HIGHWAY AND LEAD LOCAL FLOOD AUTHORITY RESPONSE TO CONSULTATION ON THE FOLLOWING DEVELOPMENT PROPOSAL

Application number: H17-0503-26

Proposal: Demolition of existing building, re-location of existing access and erection of 2 No dwellings

Location: Rear of The Mermaid Inn, 2 Gosberton Road, Surfleet, Spalding, PE11 4AB

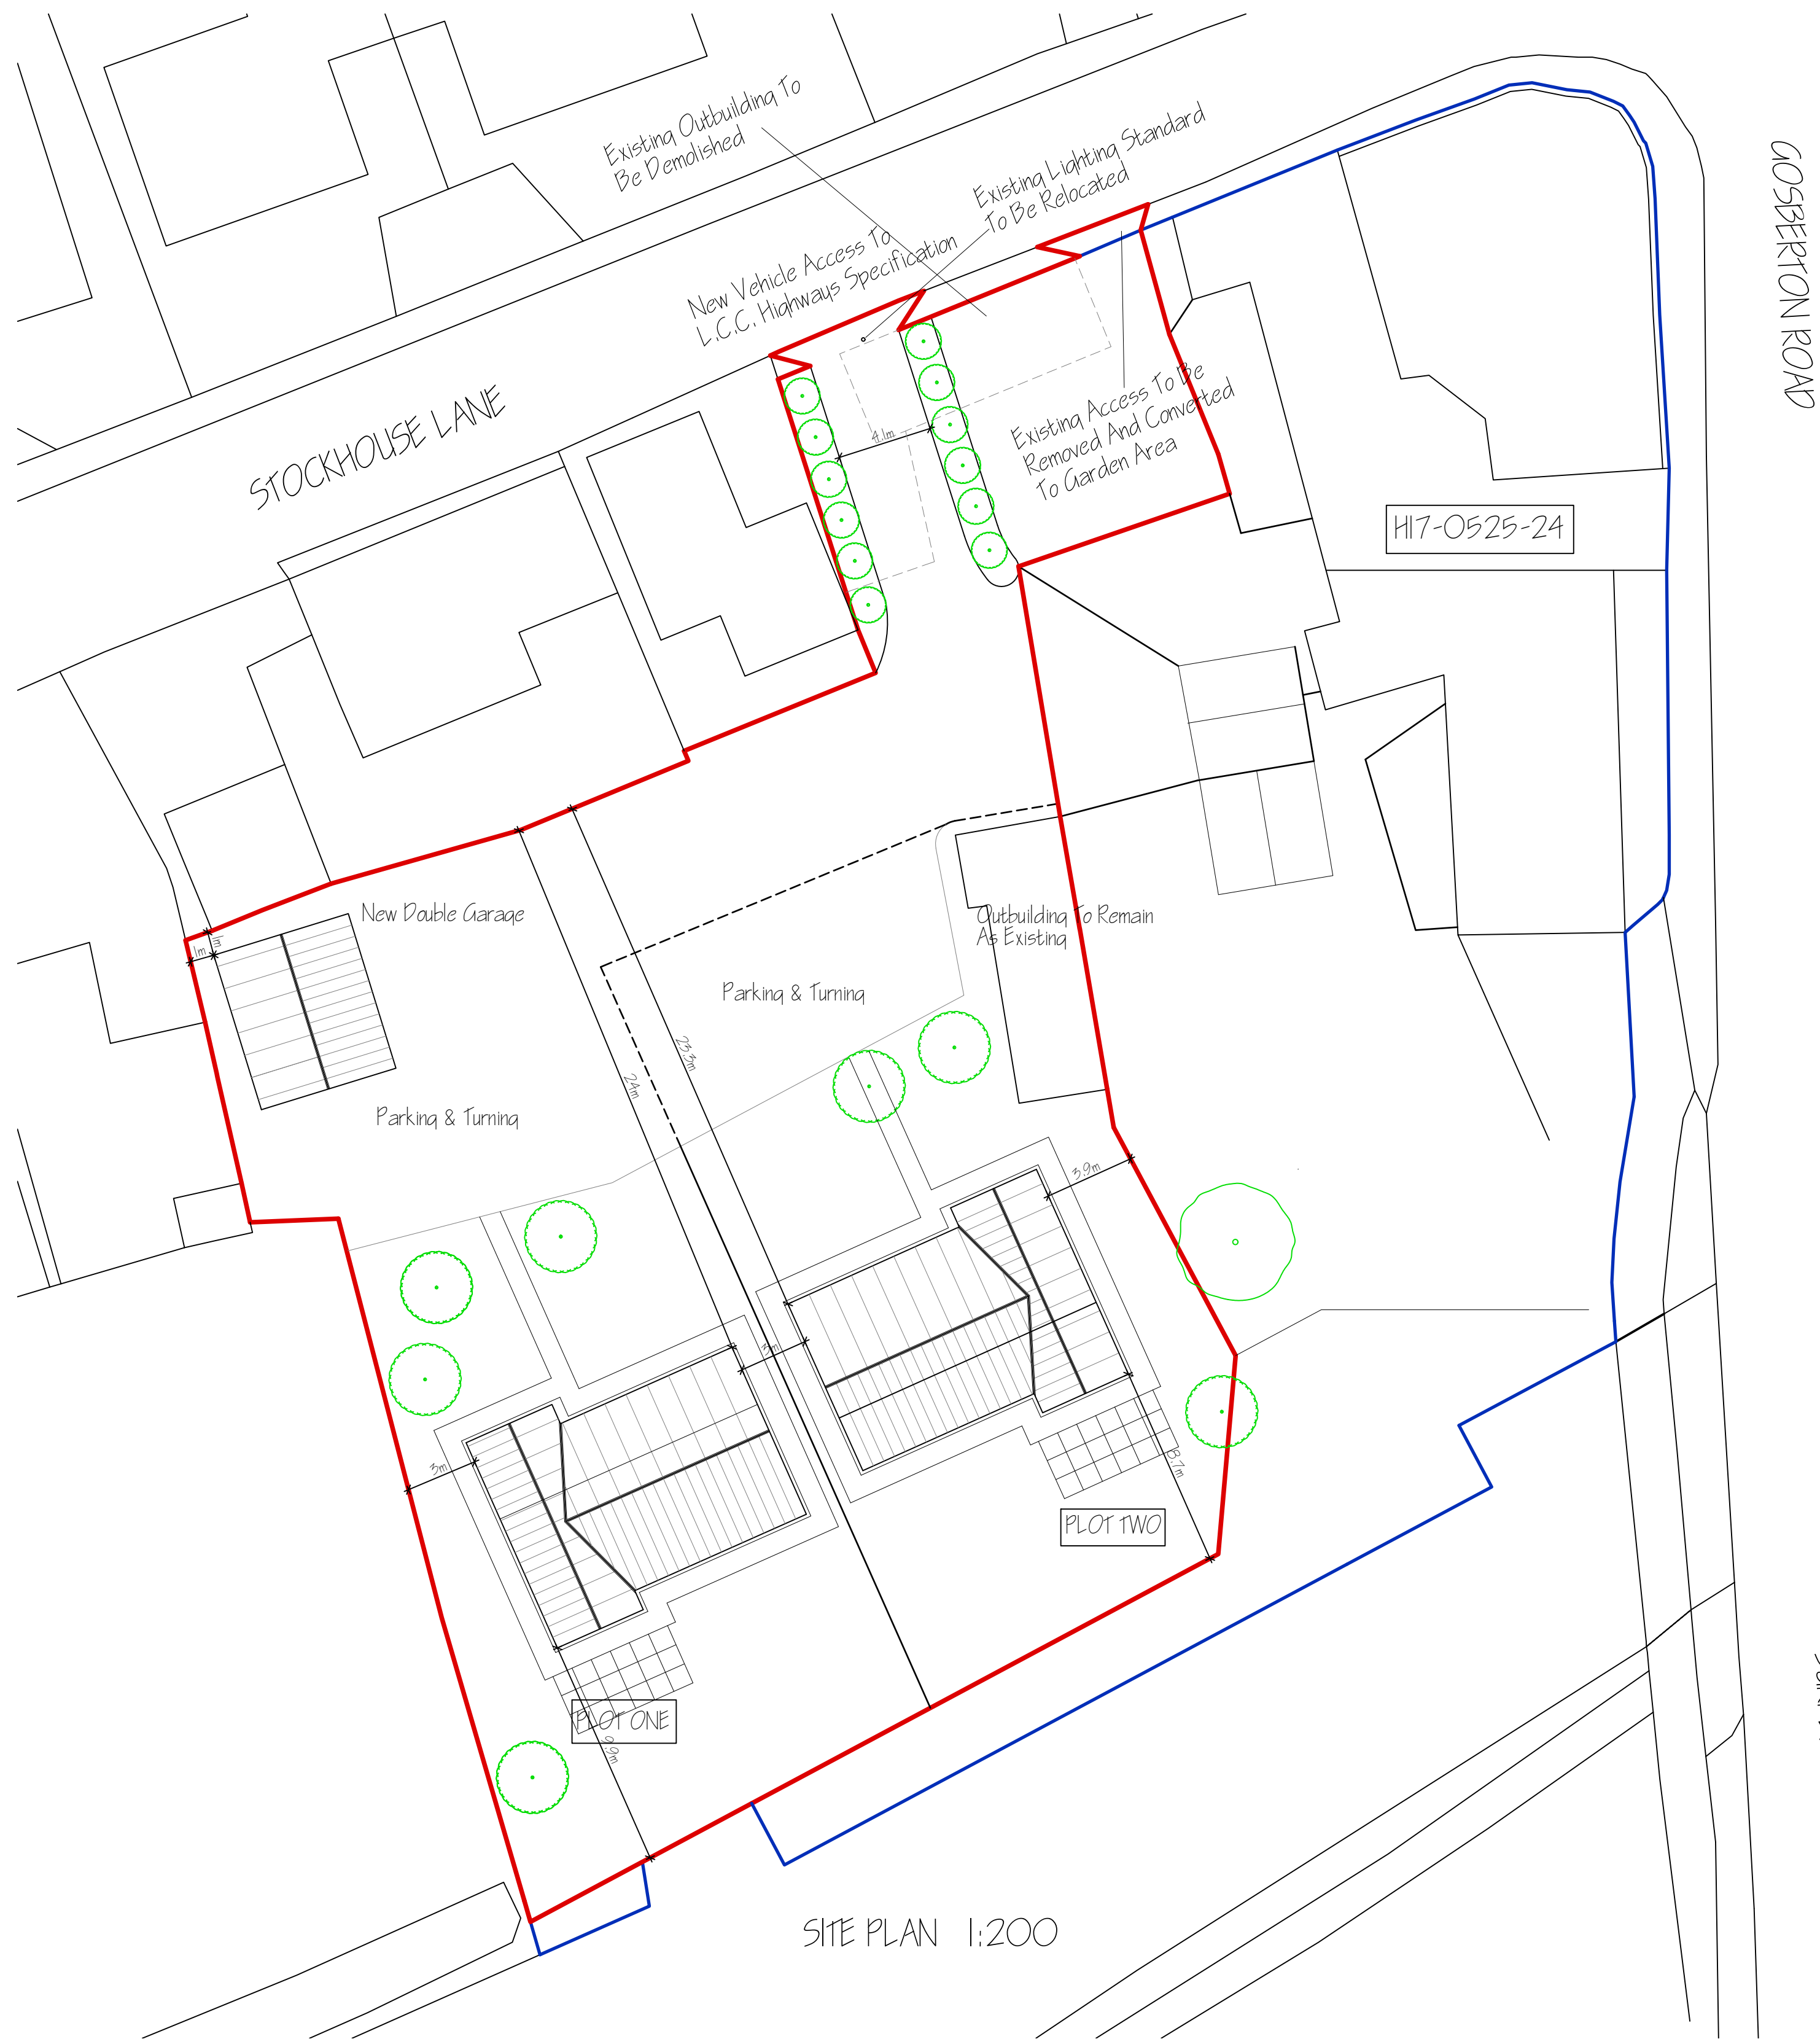
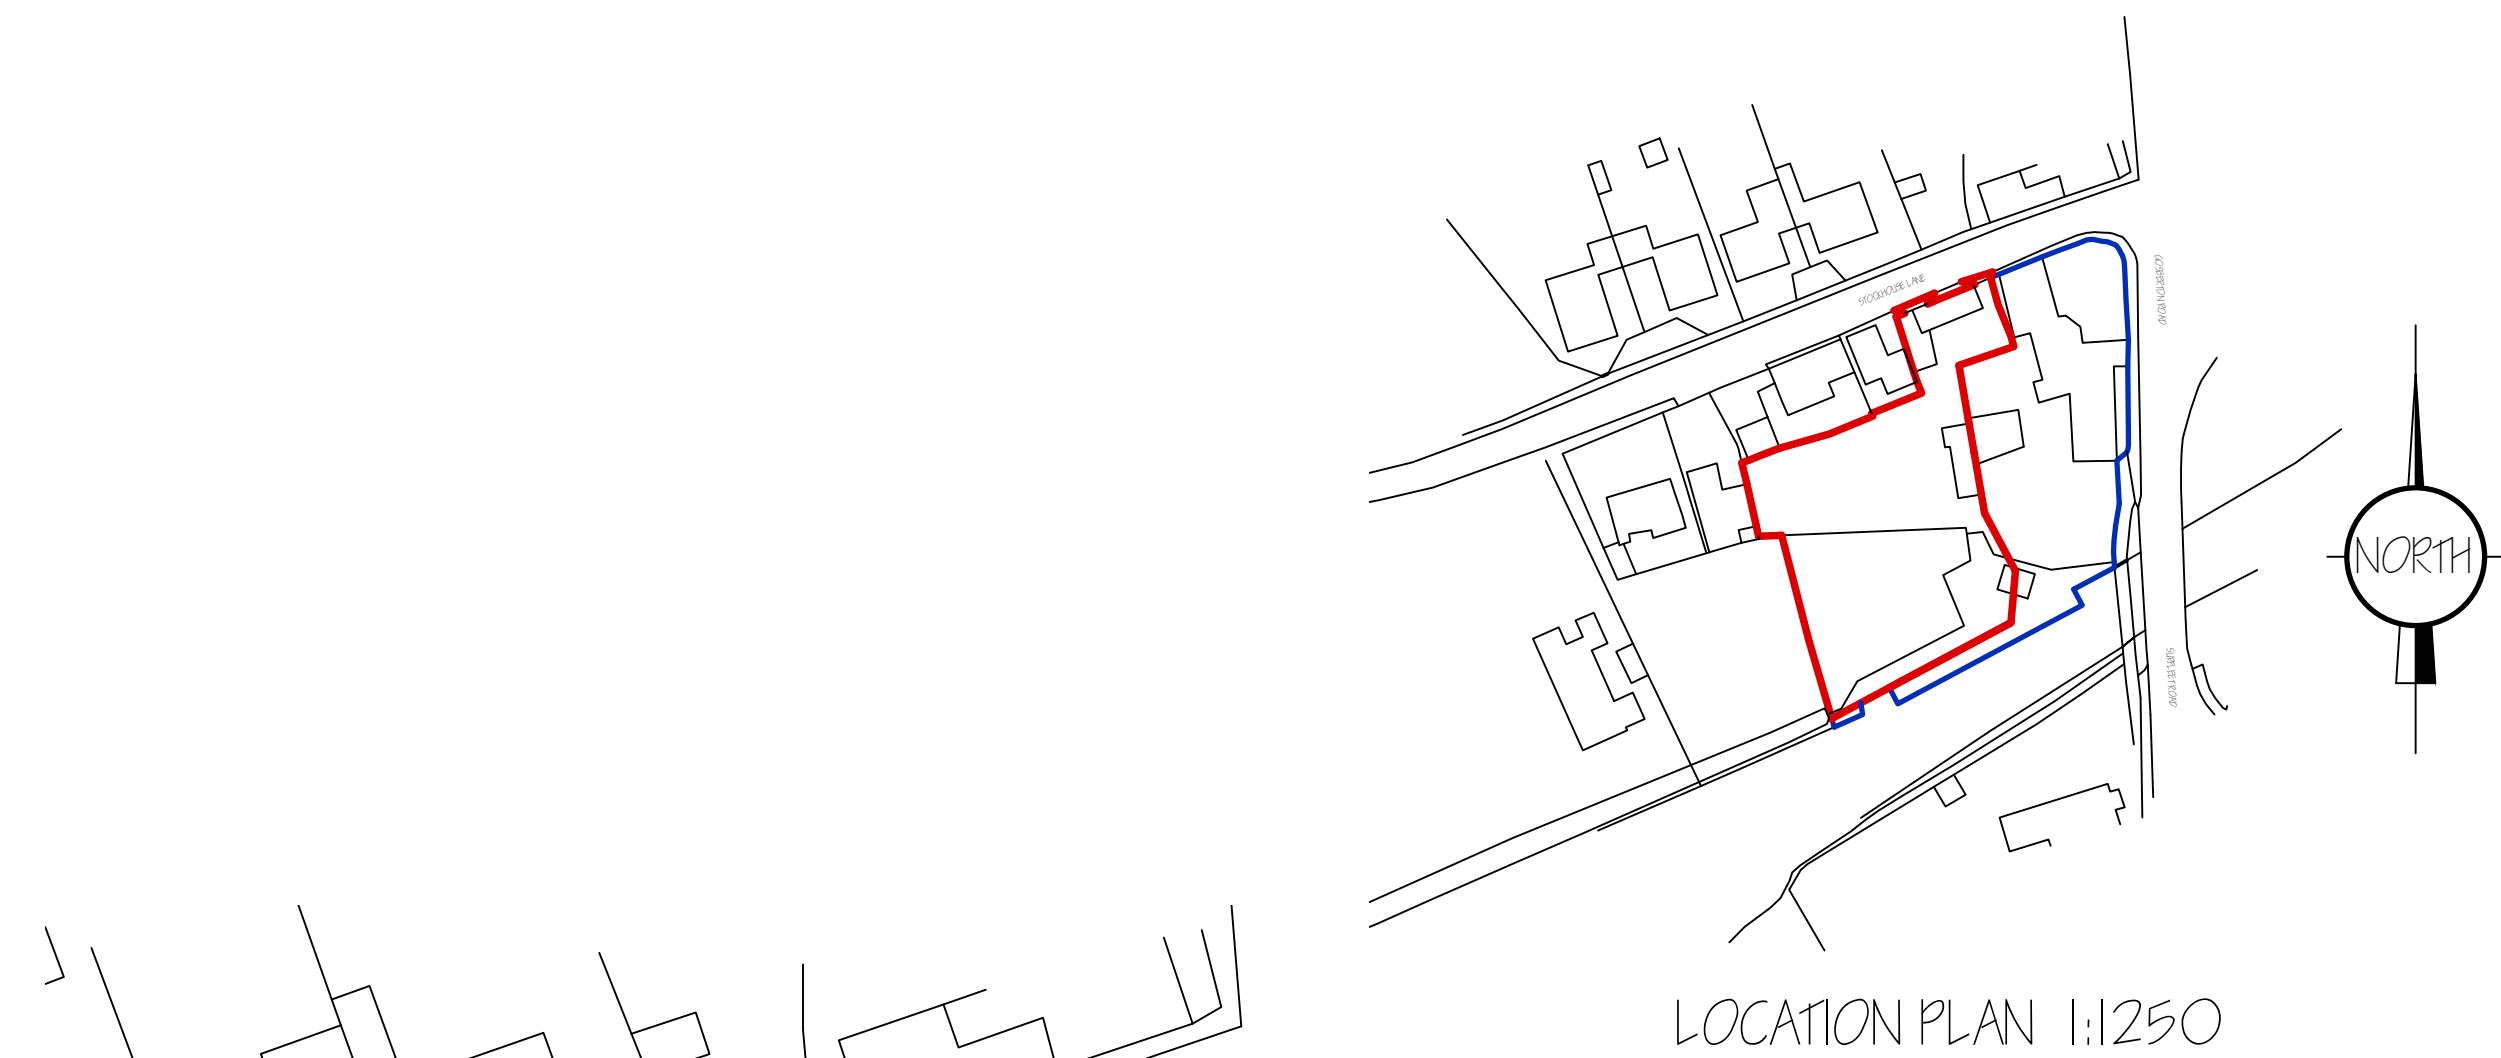
The proposal is for Demolition of existing building, re-location of existing access and erection of 2 No dwellings and it does not have an impact on the Public Highway. Sufficient visibility is provided at the new access location on Stockhouse Lane to allow drivers to judge if it is safe to complete the manoeuvre and enter the highway. Adequate provision for car parking and turning space can be provided within the limits of the site to enable vehicles to enter and leave in a forward gear and therefore, it is considered that this proposal would not result in an unacceptable impact upon highway safety. The existing access will need to be closed off and reinstated back to a full height kerb with grass verge.

Within seven days of the new access being brought into use, the existing access onto Stockhouse Lane shall be permanently closed in accordance with details to be agreed in writing with the Local Planning Authority.
